From: Judith Ward
Sent: 25 October 2021 09:10
To: Rebekah Morgan
Subject: RE: Application 21/02177/DISC: Pioneer roundabout, Graven Hill

The attached amended plans have been in response to your comments. Please can you let me know if the overcome the previous concerns and if the condition can be discharged.

**Drawing Status**  
PRELIMINARY

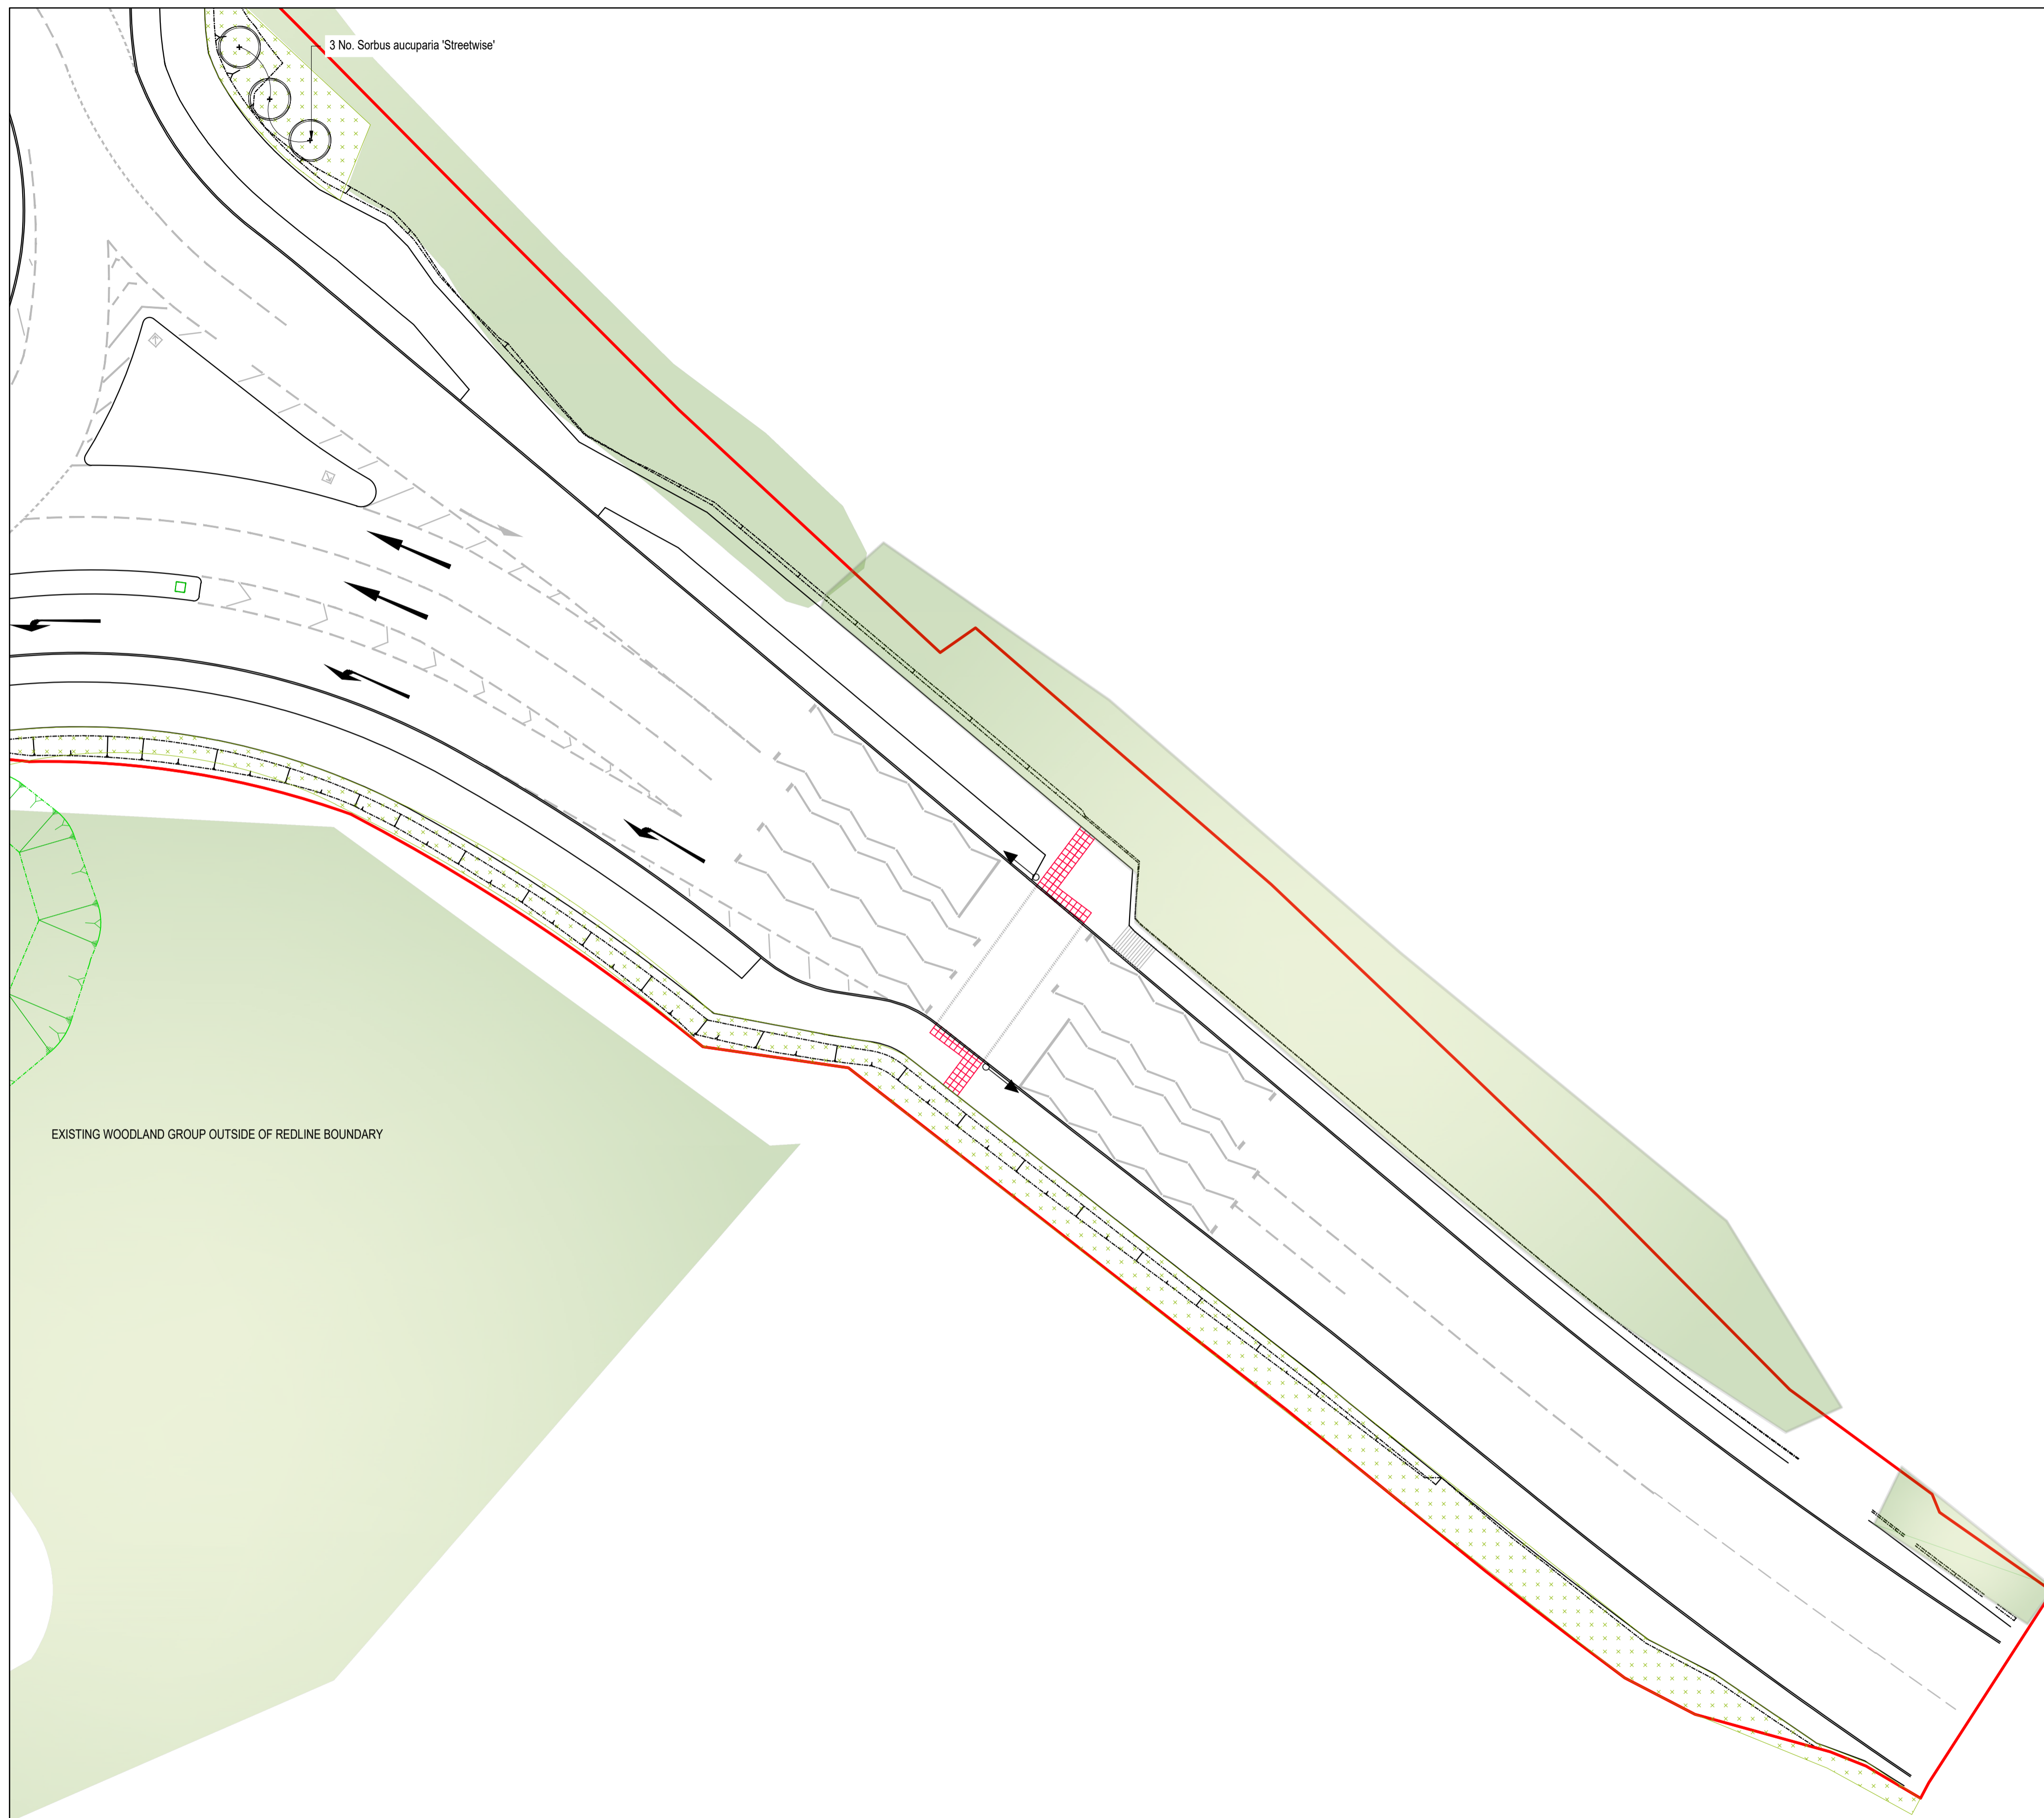
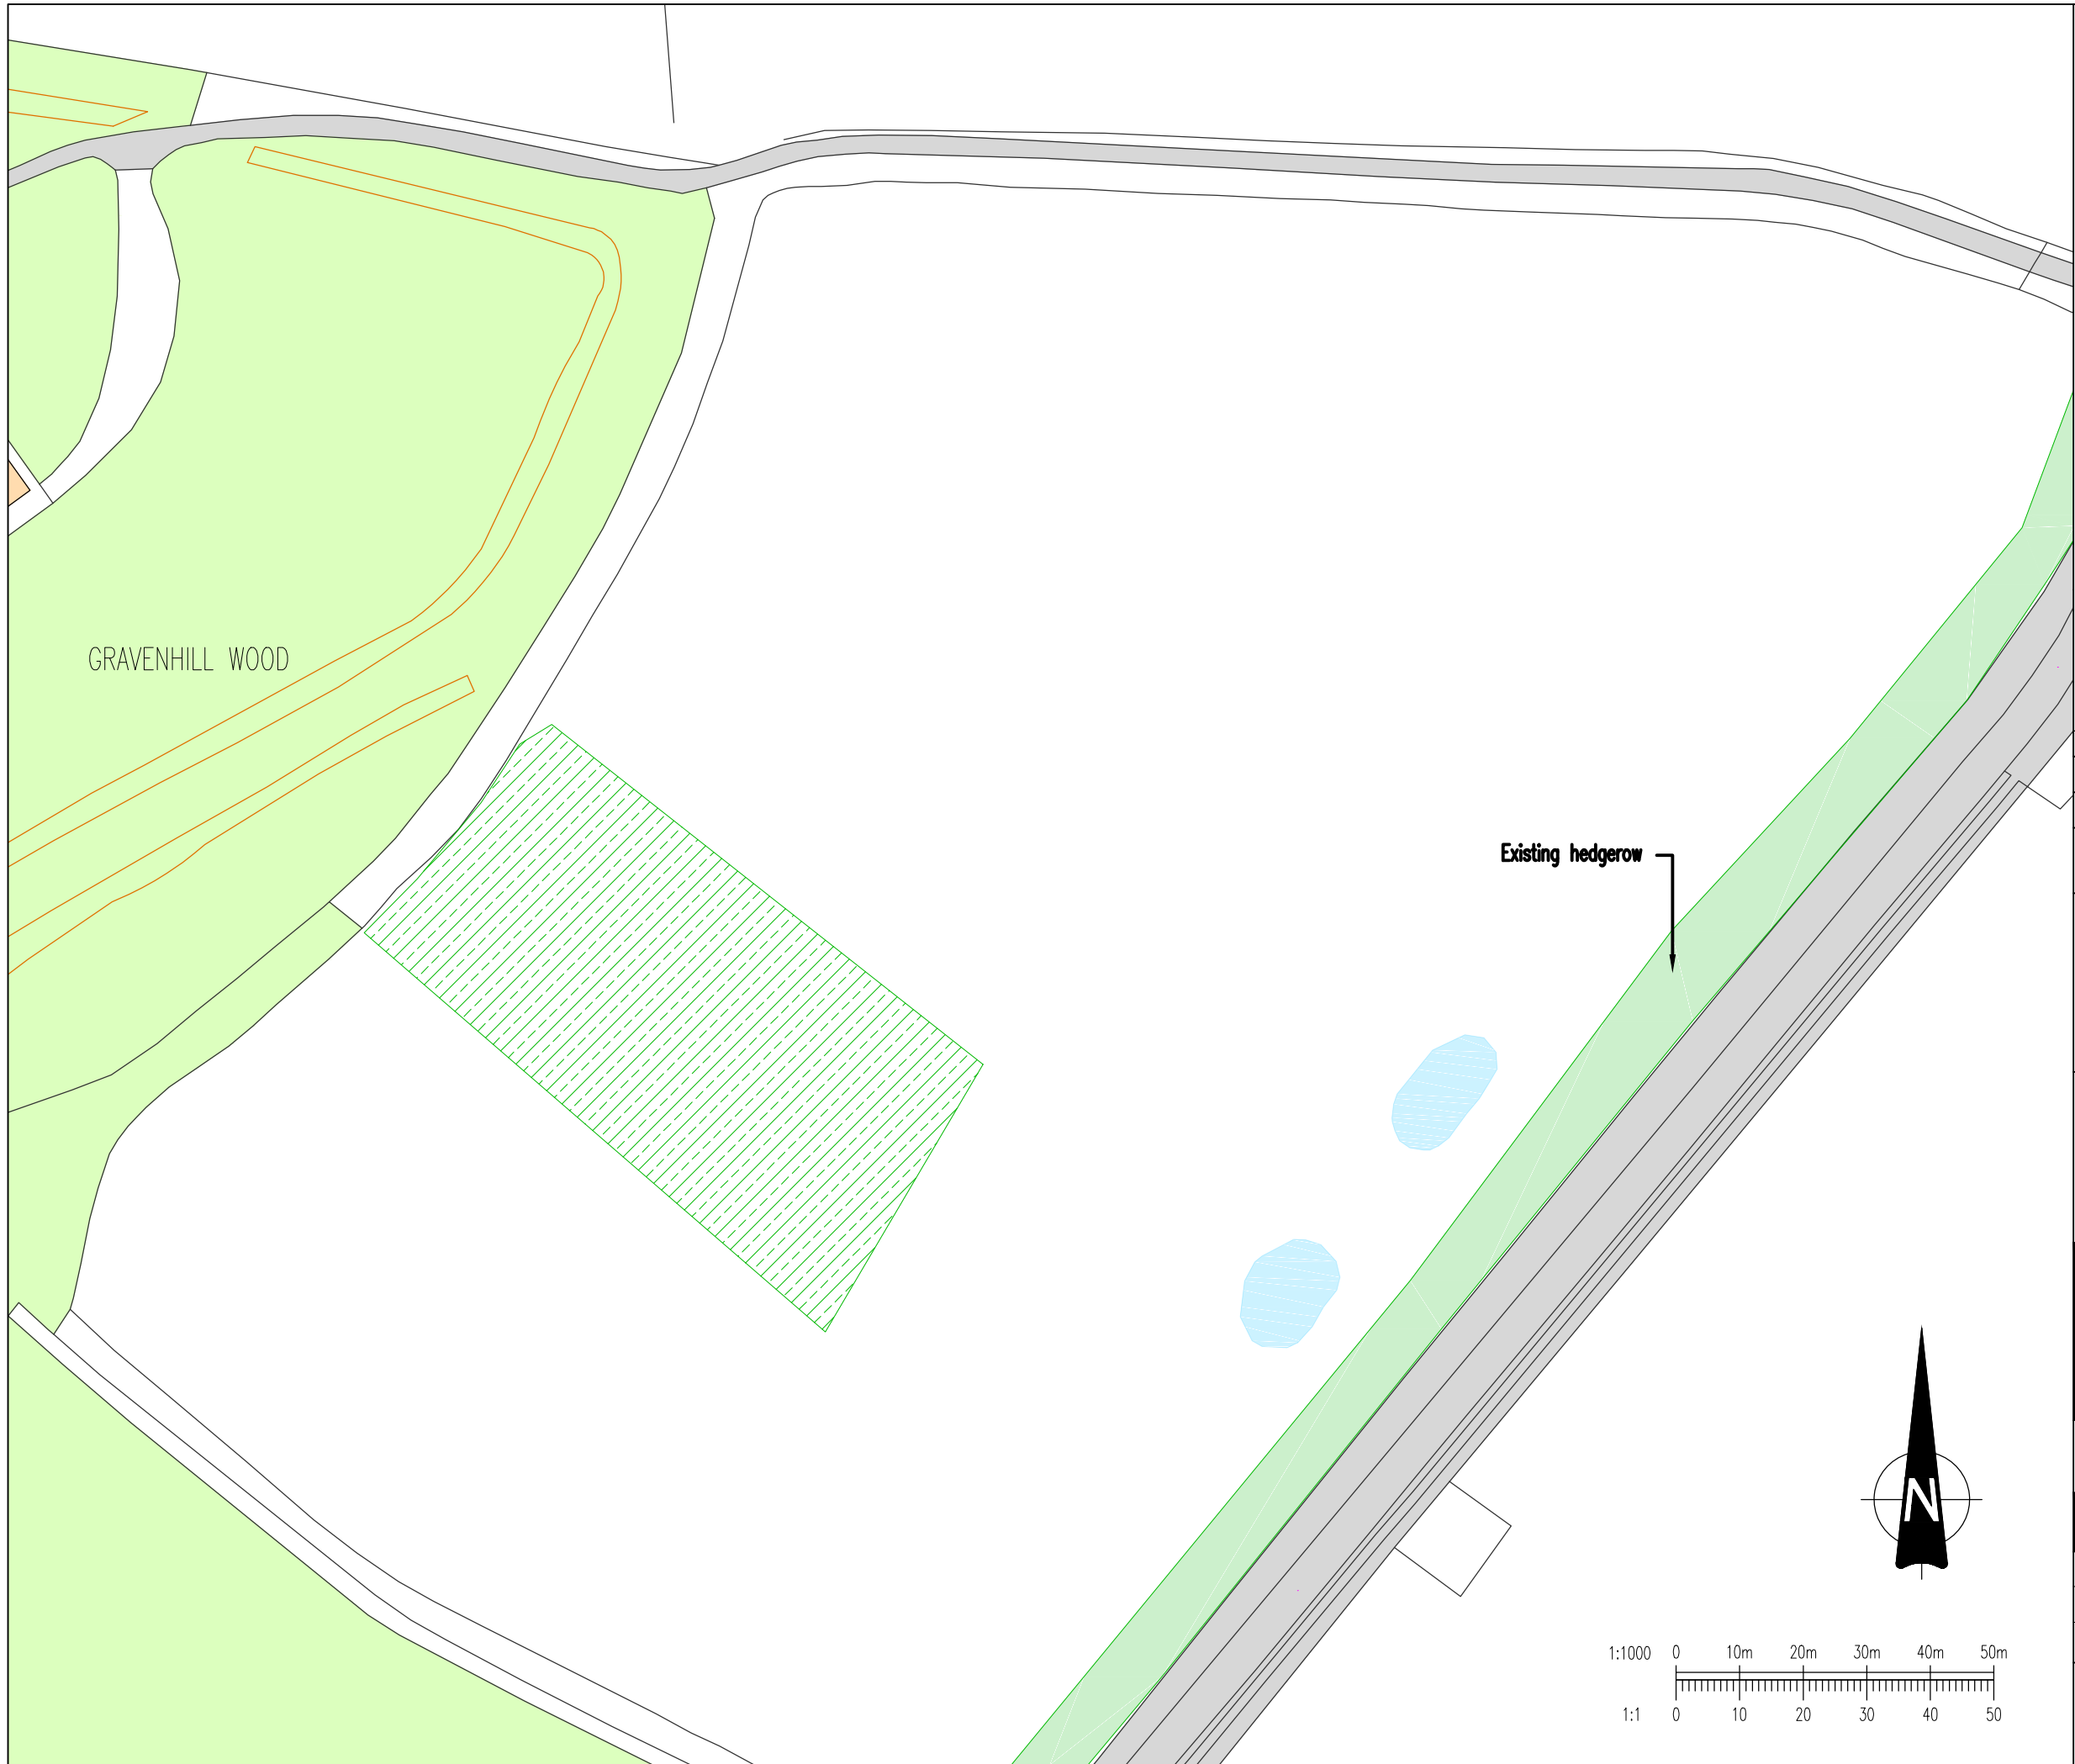
I can't see that any changes have been made.

Trees are still 14-16 I asked for larger trees at the entrance point to the site

Prunus still on plan. Prunus don't like heavy clay which we have here. They won't thrive.

Cornfield annuals still specified. Replace with perennial wild flower seed.
